**Southern
Water**

Your ref
P/42/22/DOC

Proposal: Approval of details reserved by condition imposed under P/30/19/OUT relating to conditions 5-schedule of materials and finishes, 10-surface water drainage, 11-discharge flows to watercourses, 12-maintenance and management of surface water drainage system, 14-foul drainage system, 15-external lighting, 16-Construction Management Plan, 22-existing vehicular access onto Seftor Road and Pagham Road have been physically closed, 23-plans and details and timetable for installation of dwellings, 24-pedestrian and cyclist access points, 27-Broadband provision, 29-enhancement of existing hedgerows for use by bats and 33-Electric Vehicle Charging Strategy.

Site: P/42/22/DOC: - Land North of Hook Lane, Pagham, PO21 3PD.

Private Drainage
Sheet 3 of 11

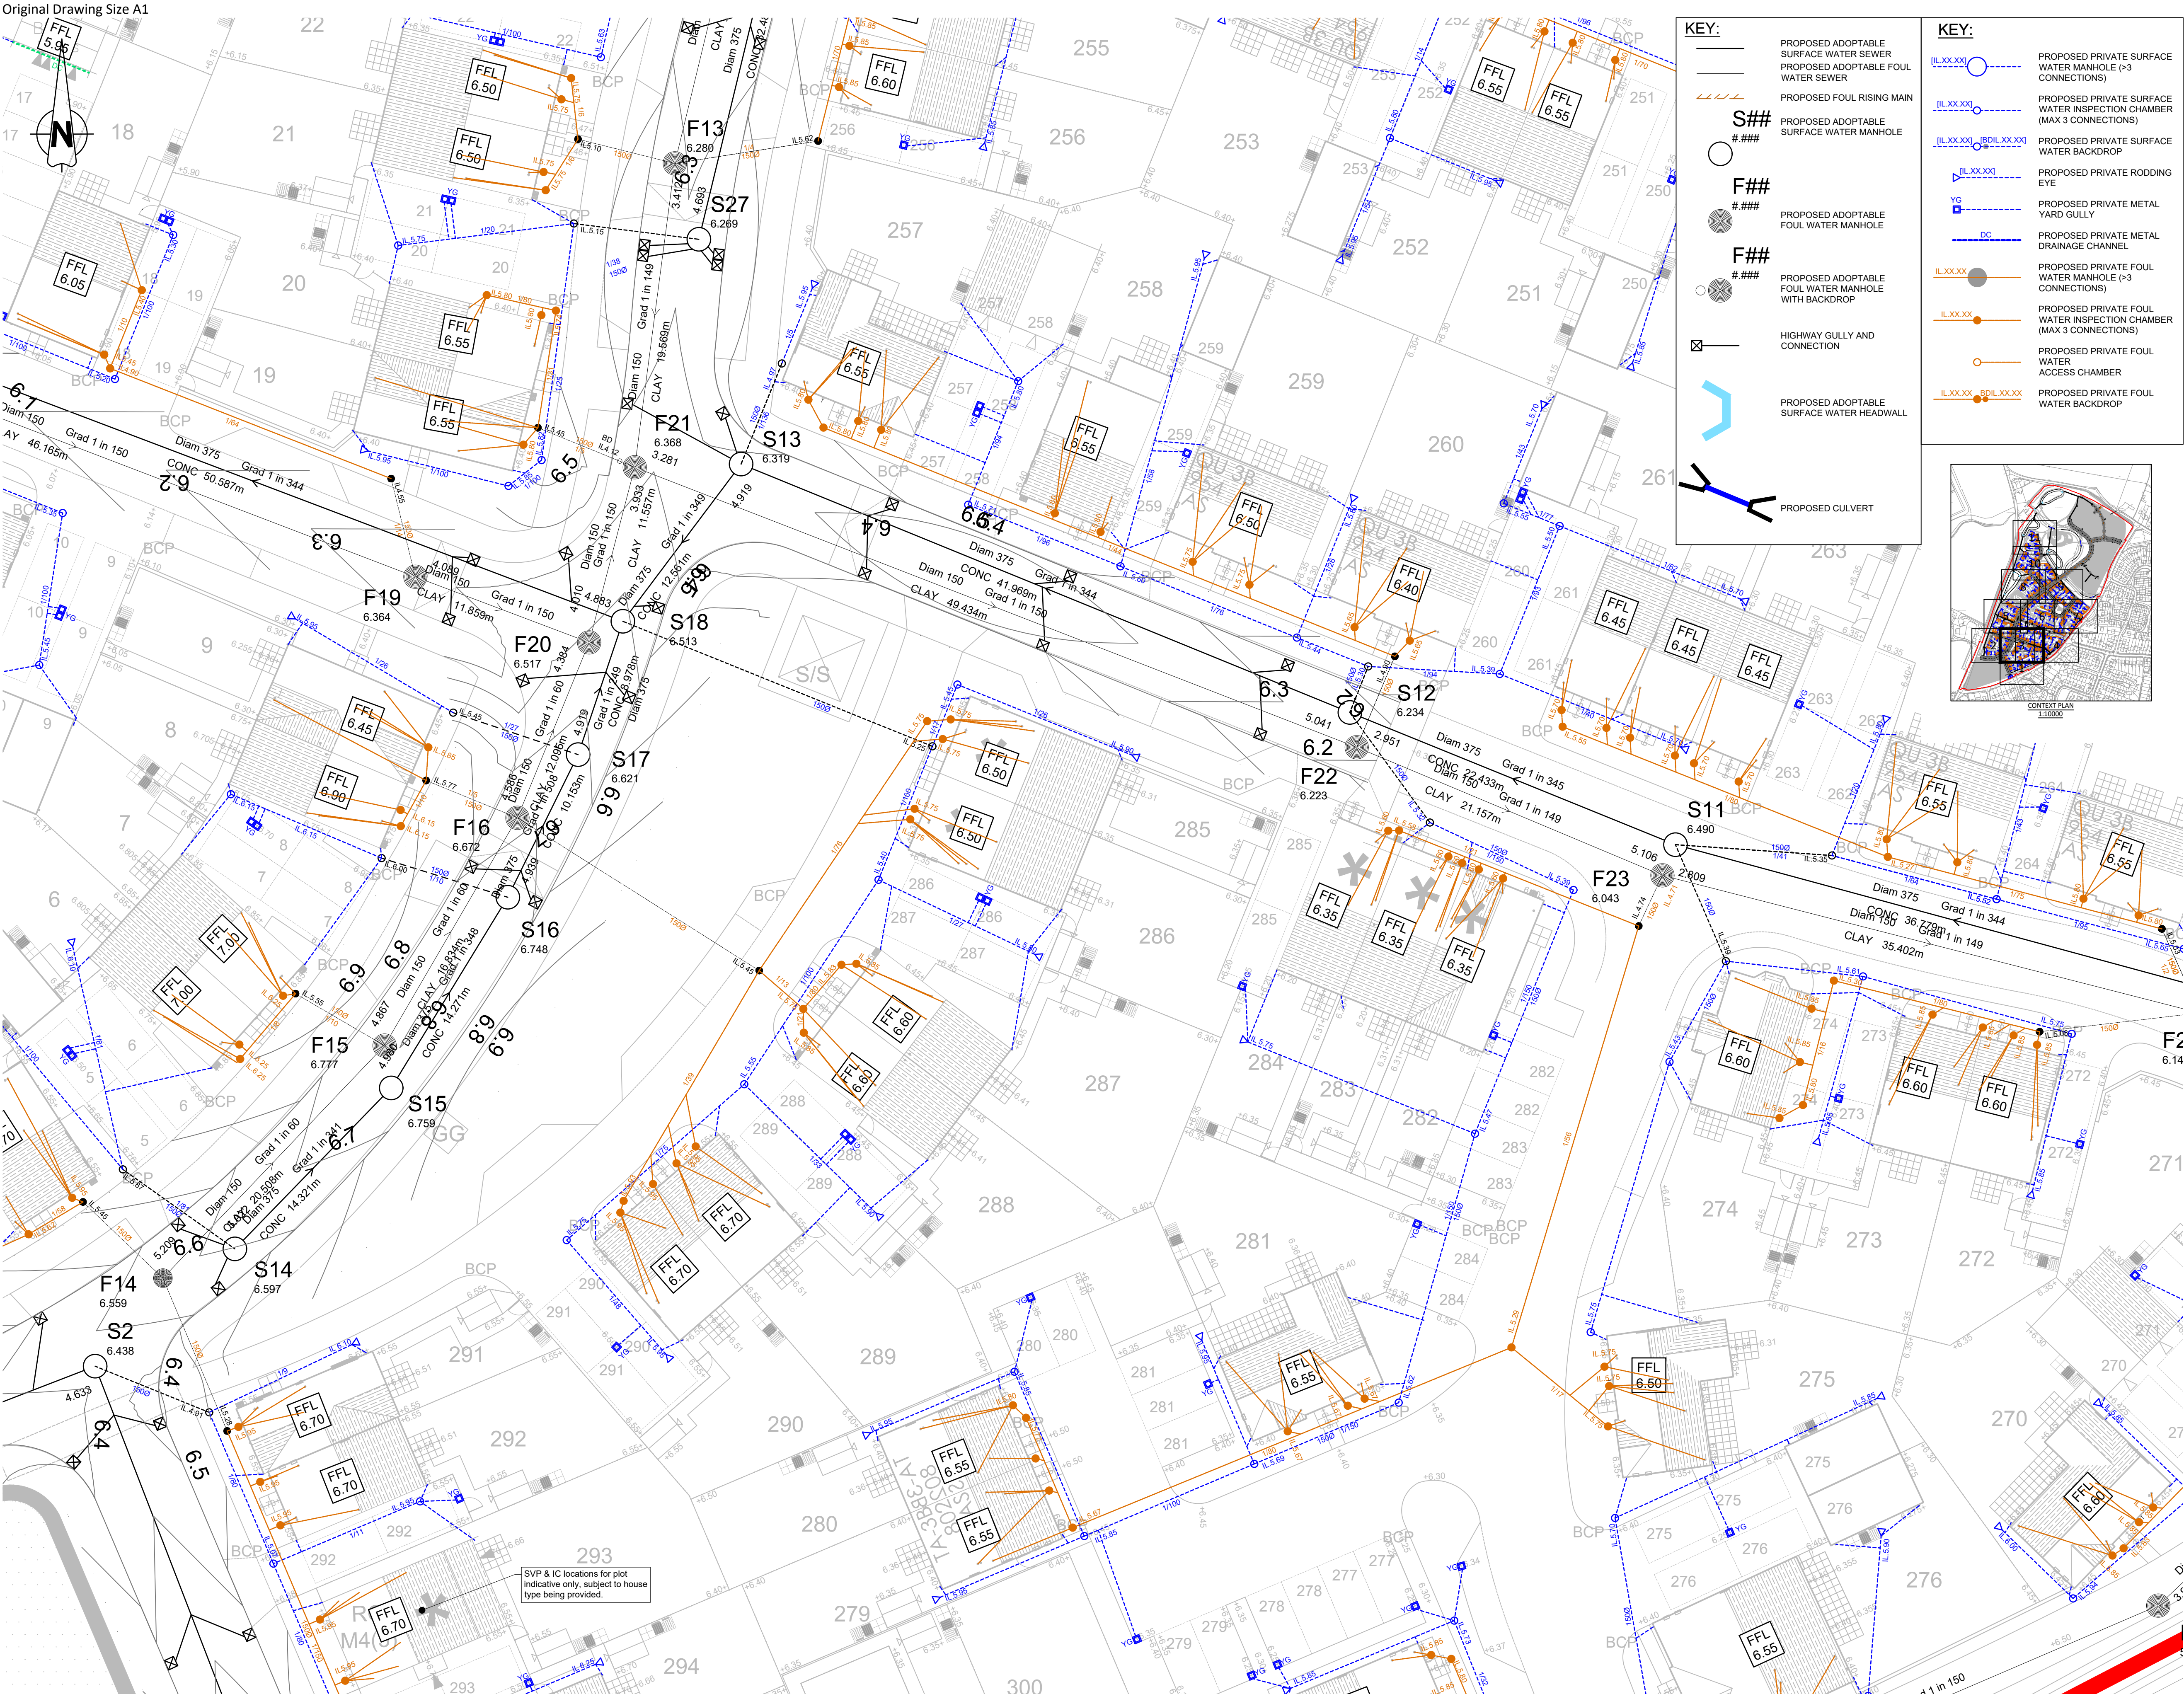
Southern Water cannot recommend discharge of condition 10, 11 and 14 relating to surface water and foul drainage. The proposed development construction over or within the standoff distance of public foul rising main which is not acceptable to Southern Water. No new development/building works will be permitted to be constructed over or within 3.0 metres of the existing sewer. The public foul rising sewer on the site needs to be diverted to maintain required standoff distance. Any public sewer diversion proposals shall be approved by Southern Water under Section 185 of the Water Industry Act. An application should be made using Southern Water's Get Connected Service at developerservices.southernwater.co.uk
